The Sizewell C Project

3.1 Draft Development Consent Order Addendum: Proposed Changes to the Draft Development Consent Order Schedules

November 2020

DRAWING TITLE:
 SIZEWELL LINK ROAD
 RIGHTS OF WAY PLANS - SHEET 19 OF 28

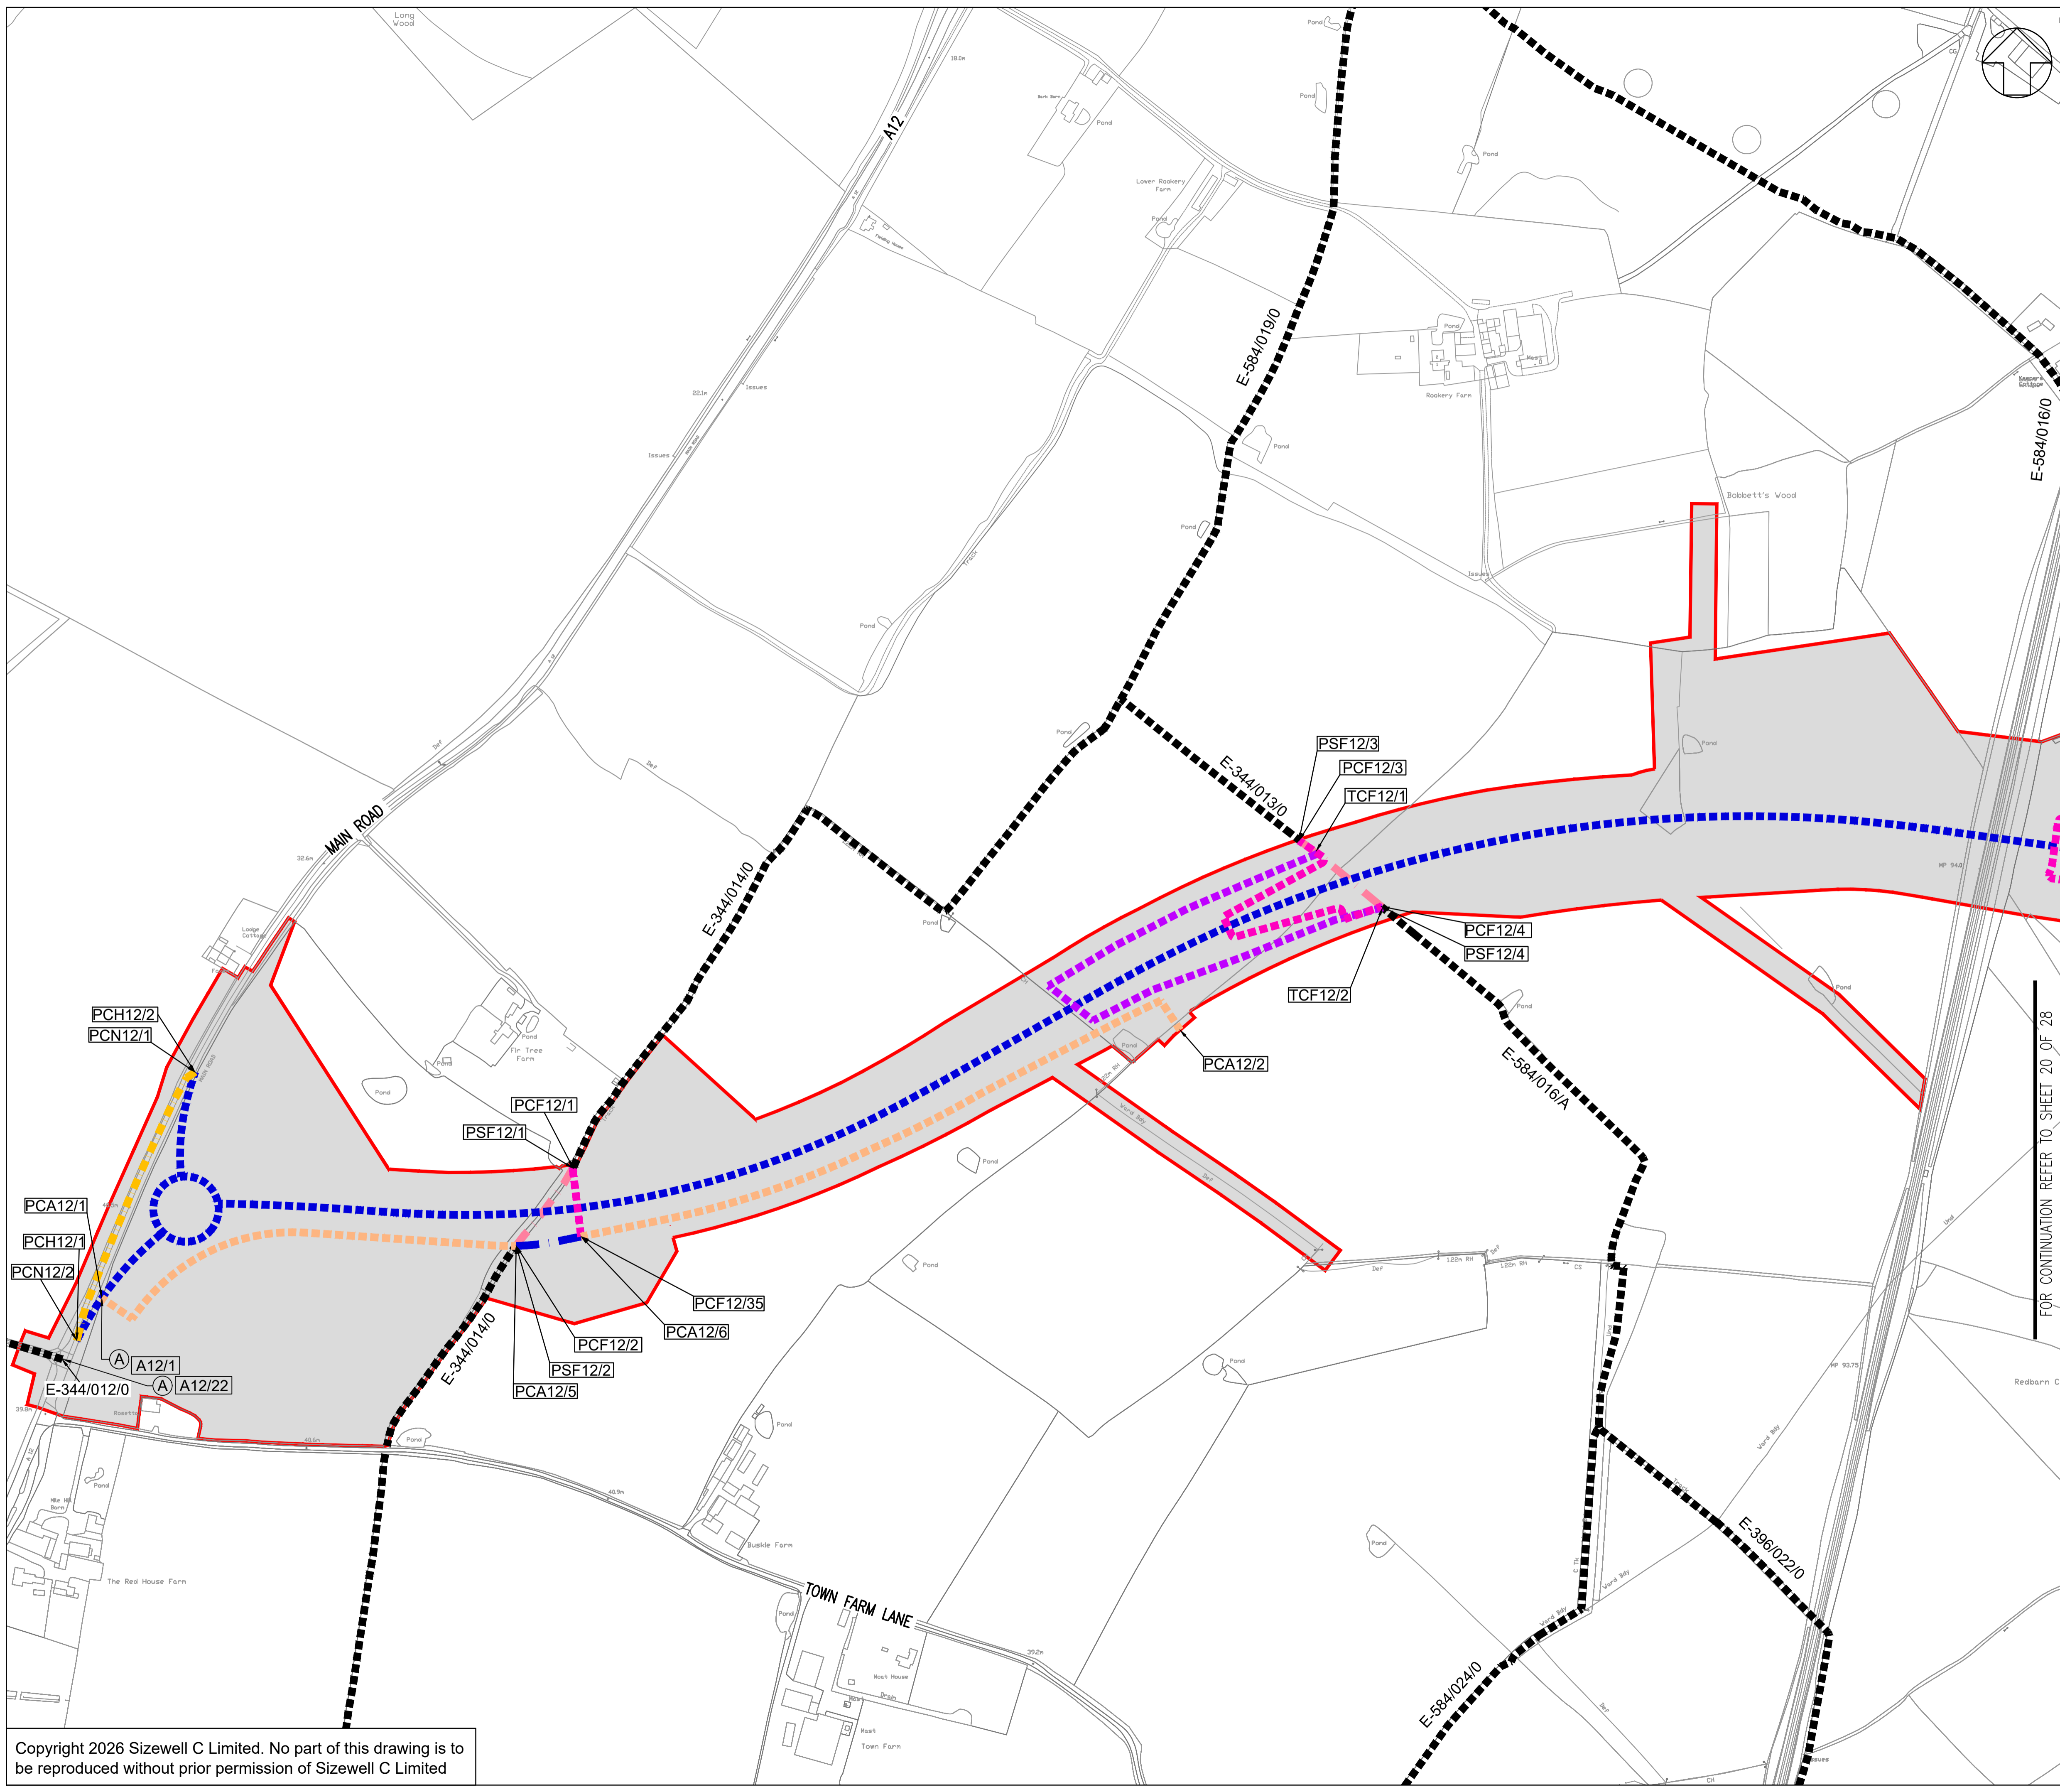
Two village bypass⁷	A12	Highway between points PSH11/15 and PSH11/16	New footpath between PCF11/5 and PCF11/6	Rights of Way Plans – sheet 18 of 27
Two village bypass	A12	Highway between points PSH11/15, PSH11/9 and PSH11/16	New highway between points PCH11/8; ⁸ PCH11/13 and PCH11/9	Rights of Way Plans – sheet 18 of 27
Two village bypass	A12	Highway between points PSH11/11 and PSH11/7	New highway between points PCH11/10 and; PCH11/13 and PCH11/8 ⁹	Rights of Way Plans – sheet 18 of 27
Two village bypass	A1094	Highway between points PSH11/14 and PSH11/9	Highway between points PCH11/11; PCH11/13; PCH11/8; ¹⁰ PCH11/9 and PCH11/10	Rights of Way Plans – sheet 18 of 27
Sizewell link road	A12	Highway between points PSH12/1 and PSH12/2	New highway between points PCH12/1 and PCH12/2	Rights of Way Plans – sheet 19 of 27
Sizewell link road	Footpath E-344/014/0	Footpath between points PSF12/1 and PSF12/2	New footpath between points PCF12/3 and PCF12/4	Rights of Way Plans – sheet 19 of 27

NORTHERN PARK AND RIDE
RIGHTS OF WAY PLANS - SHEET 15 OF 27

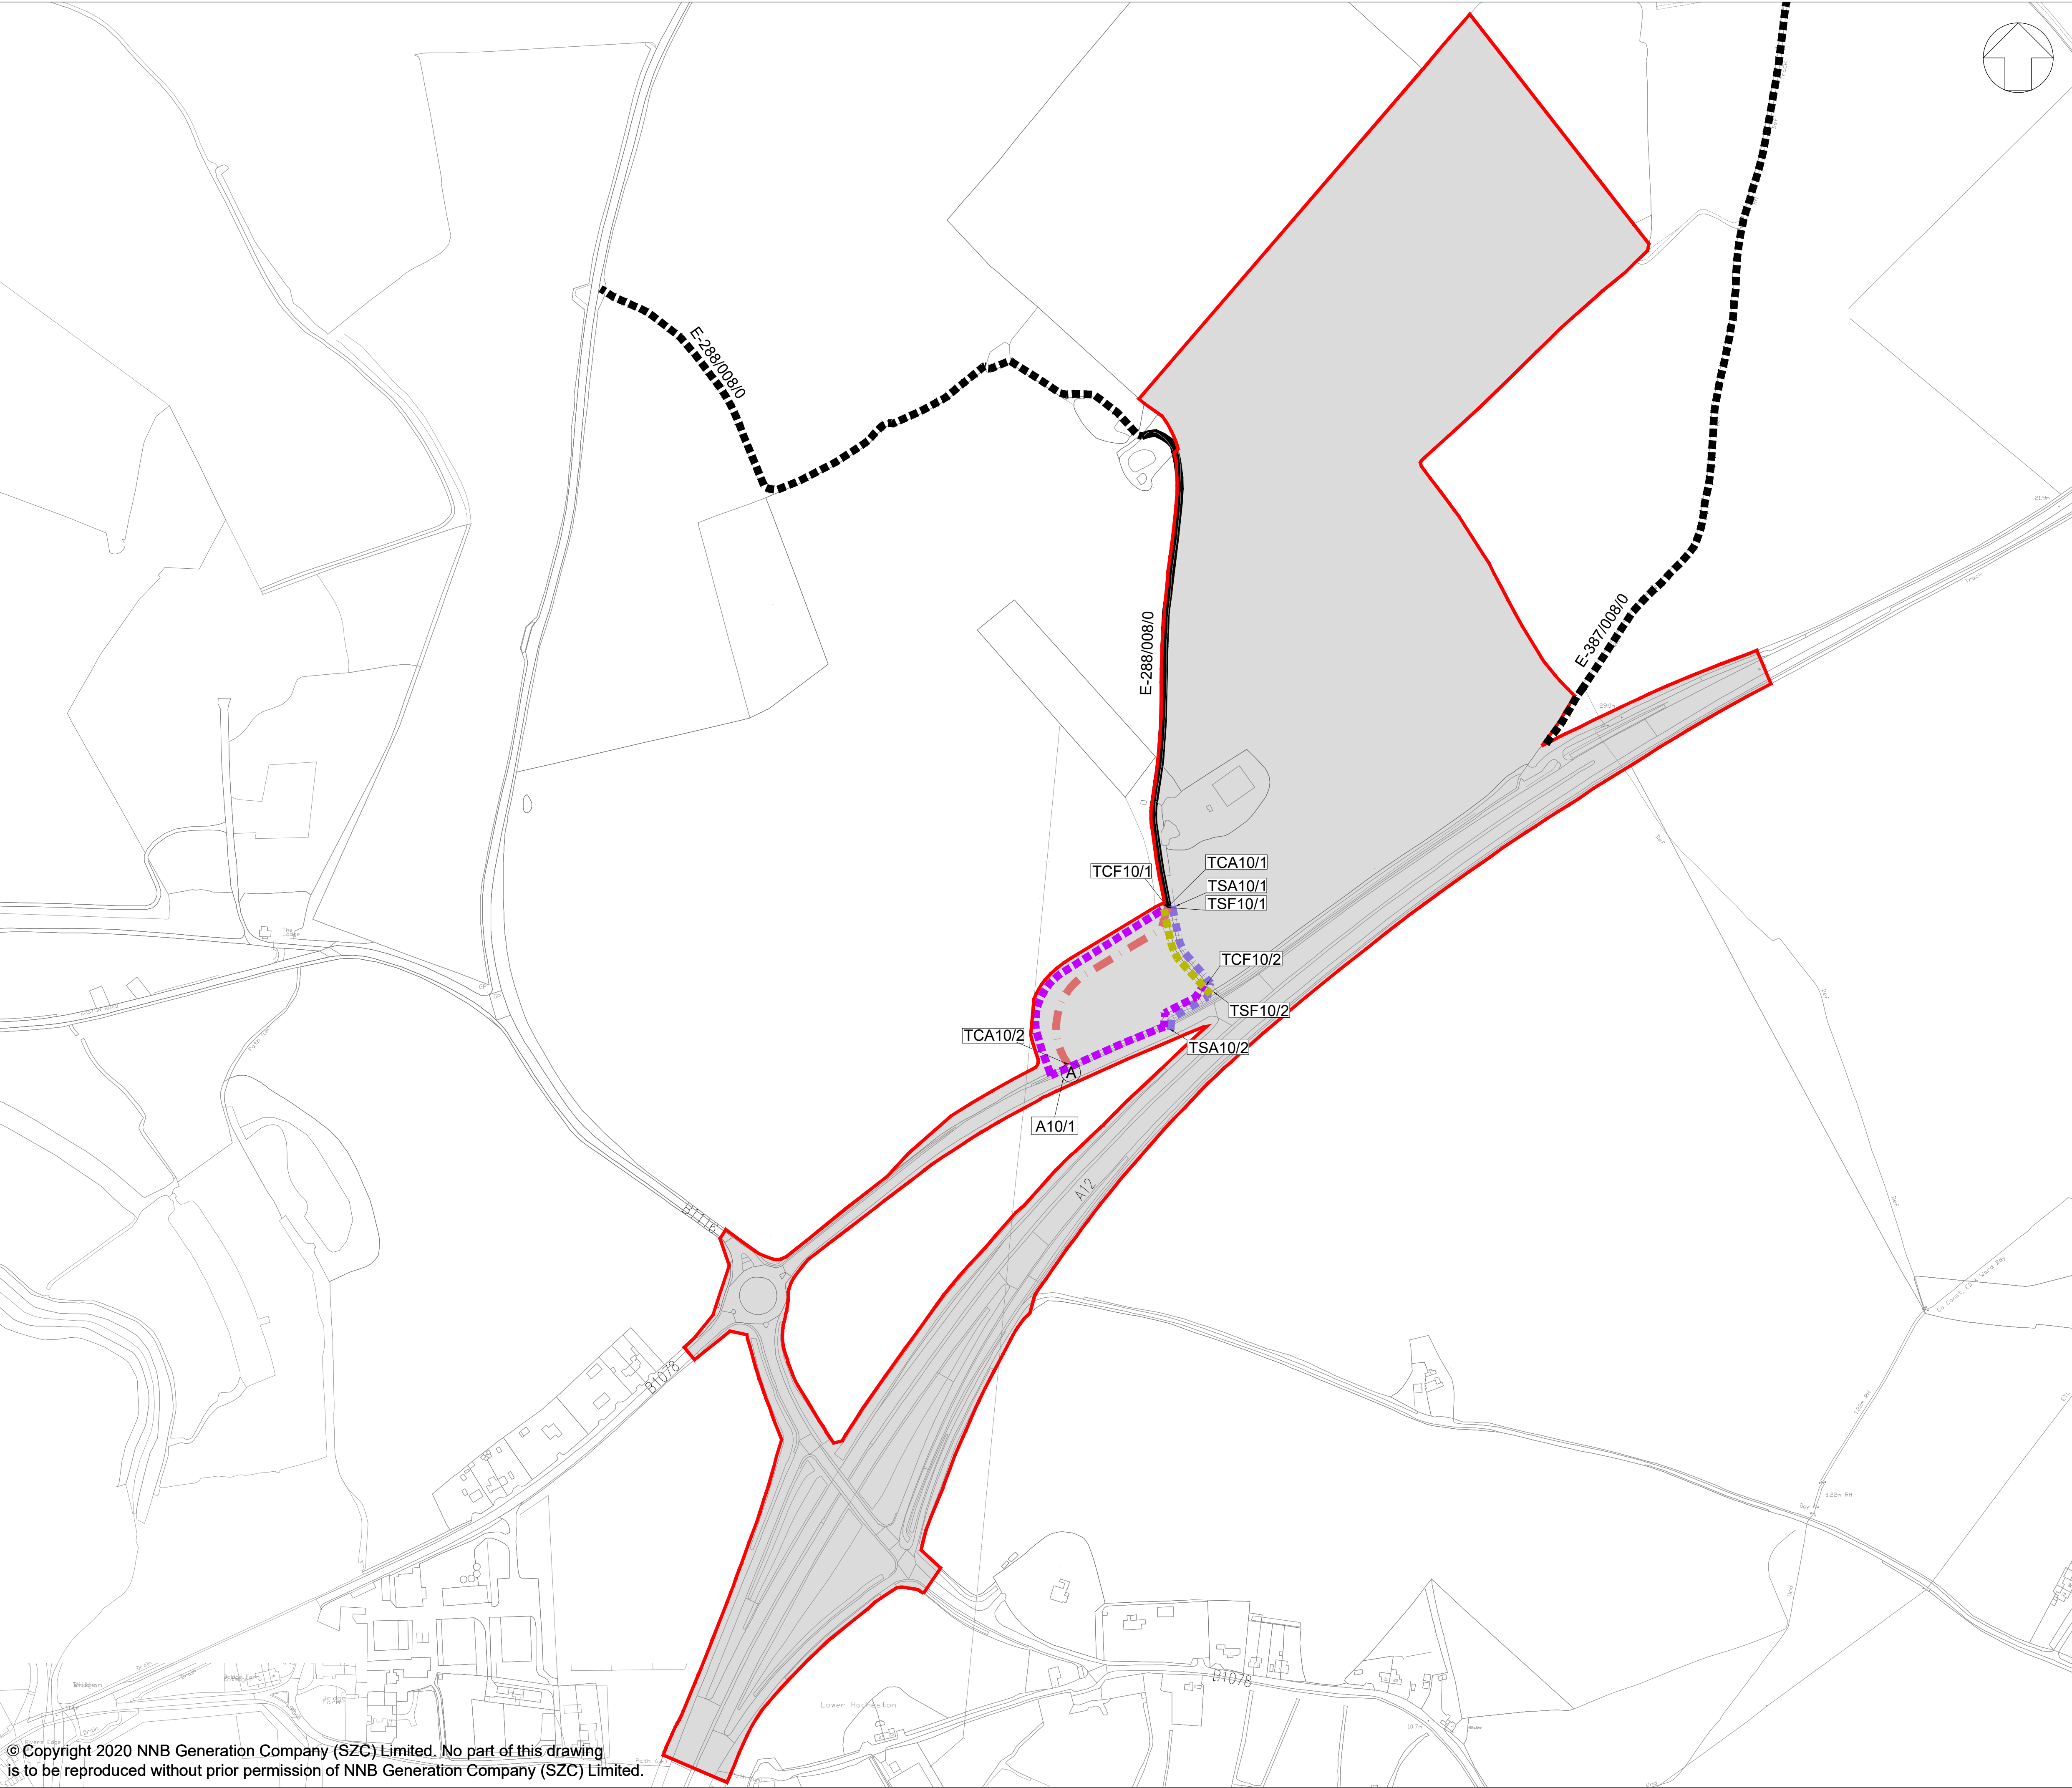
Northern Park and Ride – Schedule 13 – Sheet 15 of 27	<ul style="list-style-type: none"> Addition of TCH9/1 within line 'Willow Marsh Lane' Reference to TSH9/2 corrected to TCA9/2

²⁵ TCH9/1 omitted in error – now corrected.

²⁶ Reference to ‘TSH9/2’ was in error – now corrected to TCA9/2.
